9 July 2023

RE: Consultation on planning application 3/2023/0274 – Laneside Barn, Grindleton Road, Grindleton BB7 4QH

Drawing Title:
Proposed Site Plan

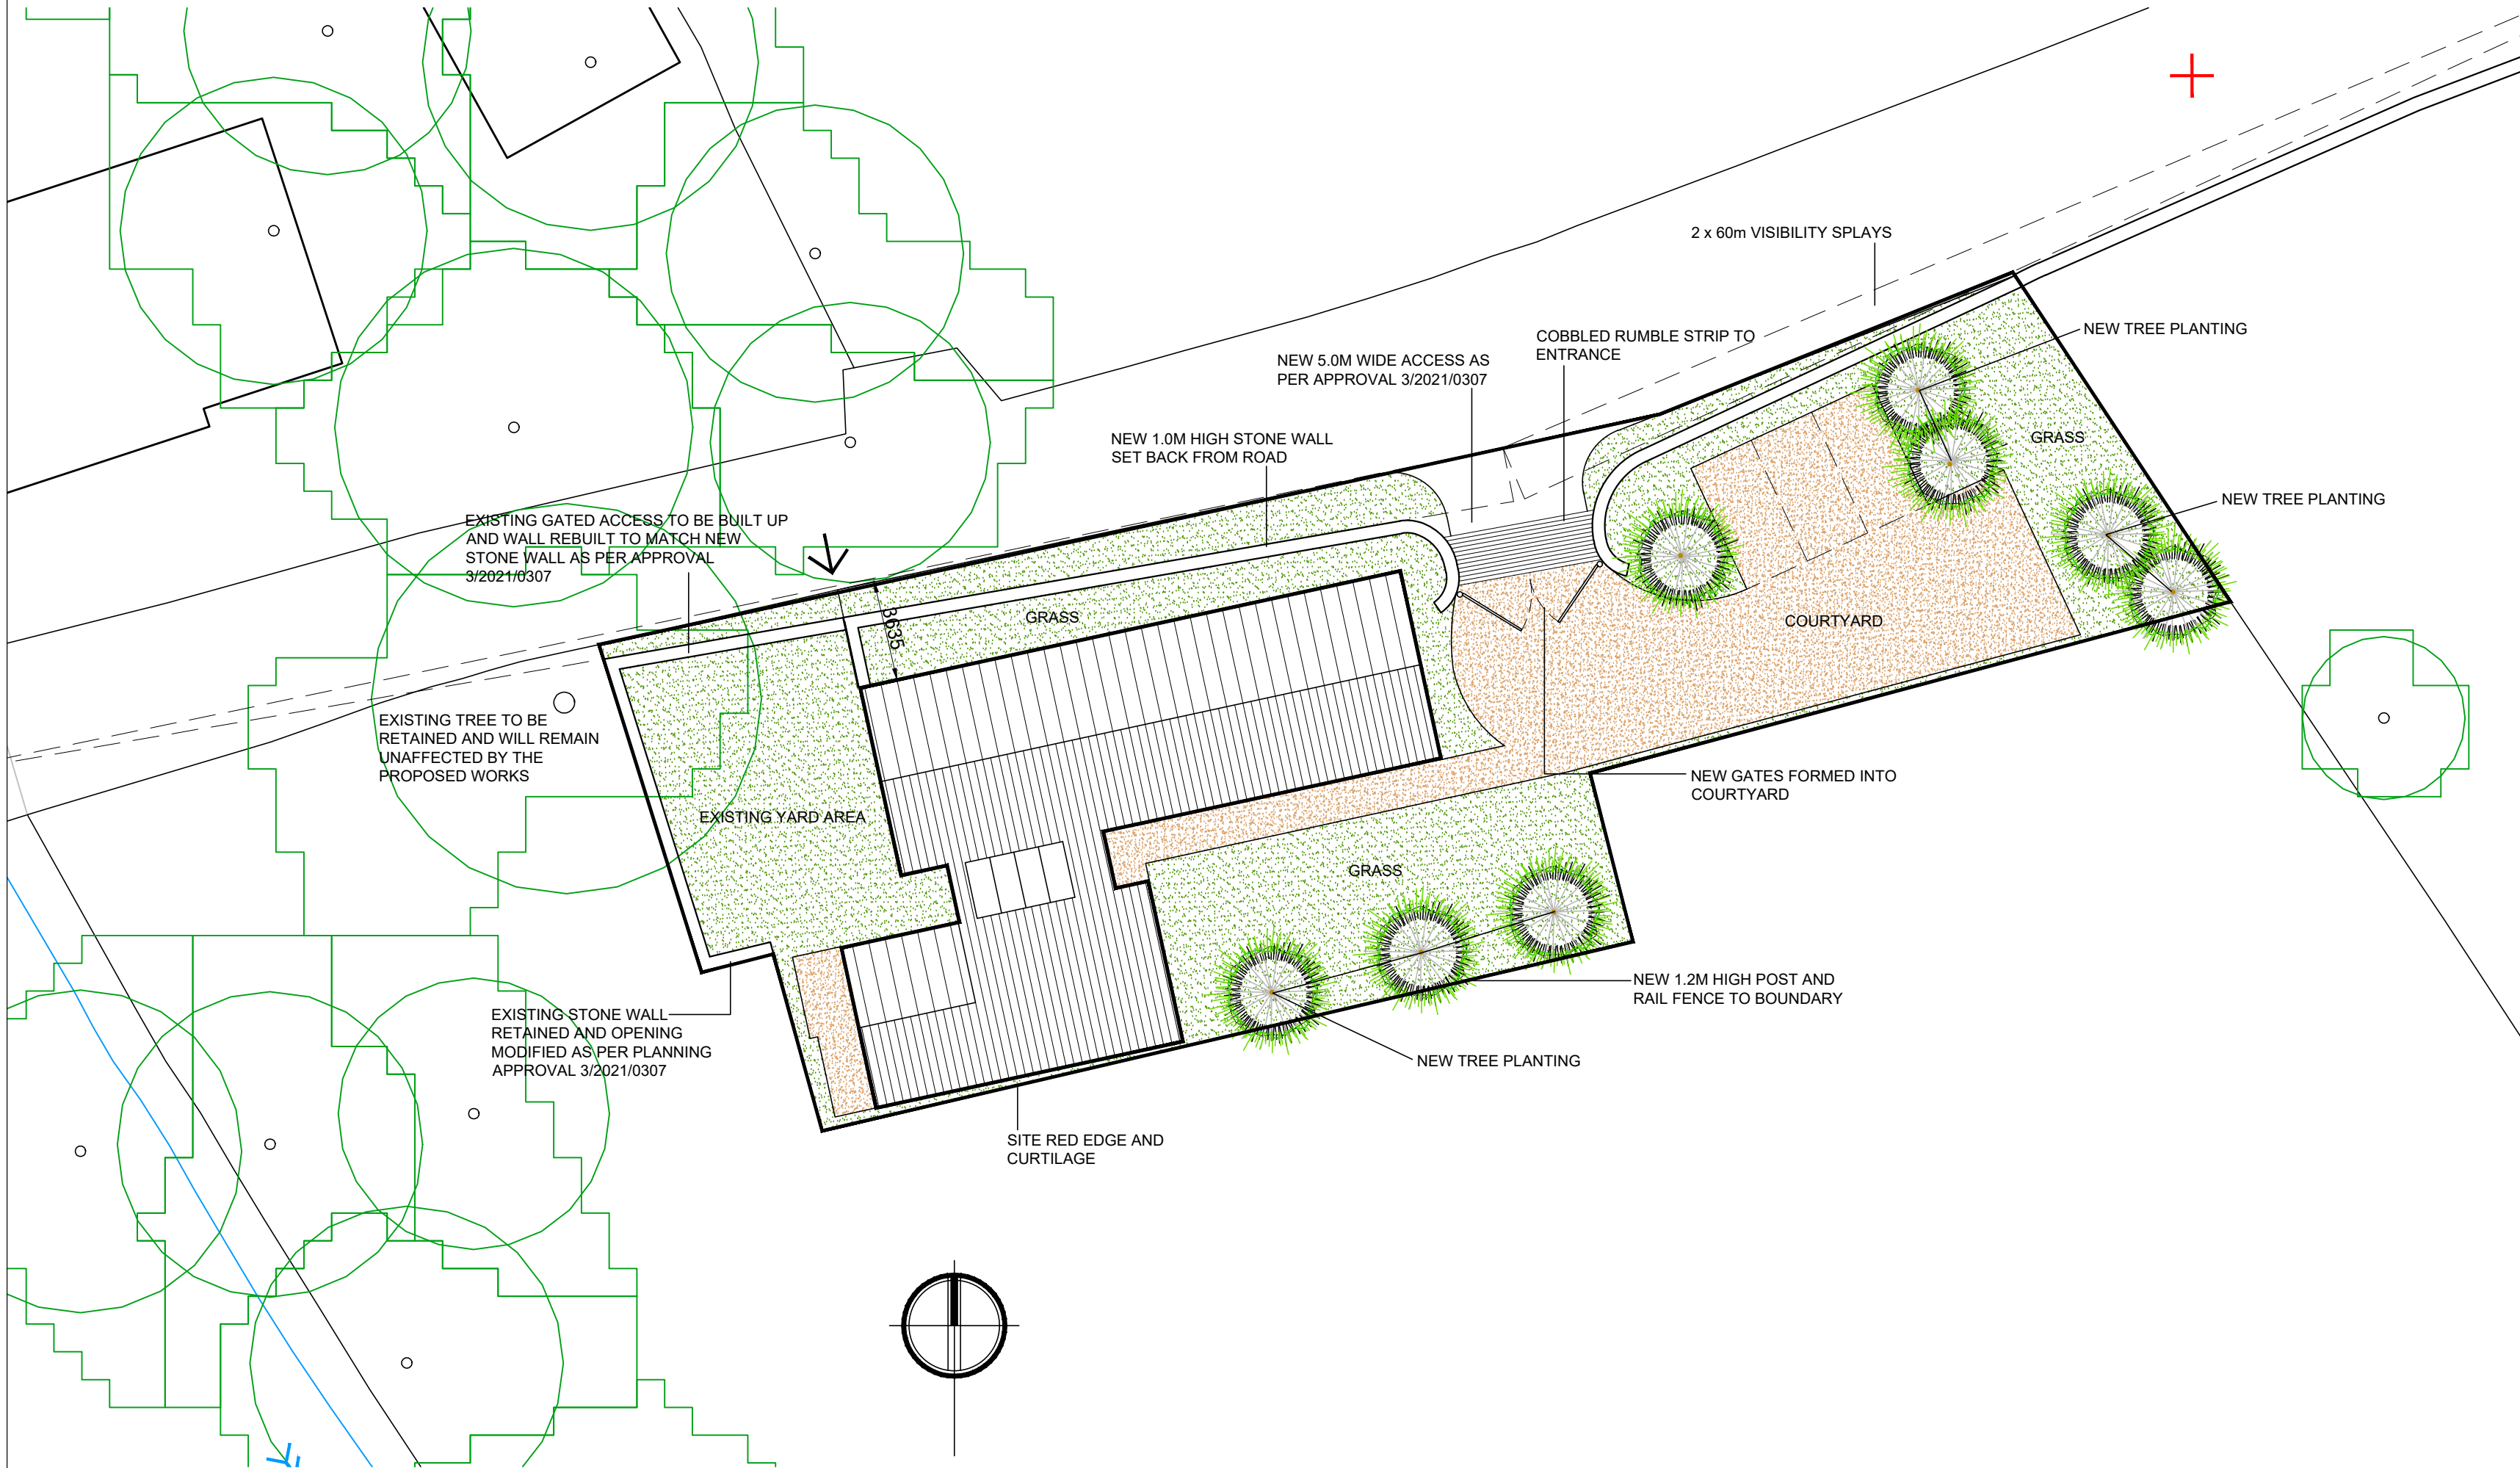
One of the main benefits said to arise from the proposed demolition and rebuild would be the re-location of the property some 3.6m back from Grindleton Rd, thereby increasing road safety. However, members noted that concerns about access from the highway had been considered in application 3/2021/0307, when the existing structure had been retained, with road safety concerns not being sufficiently great to merit refusal.
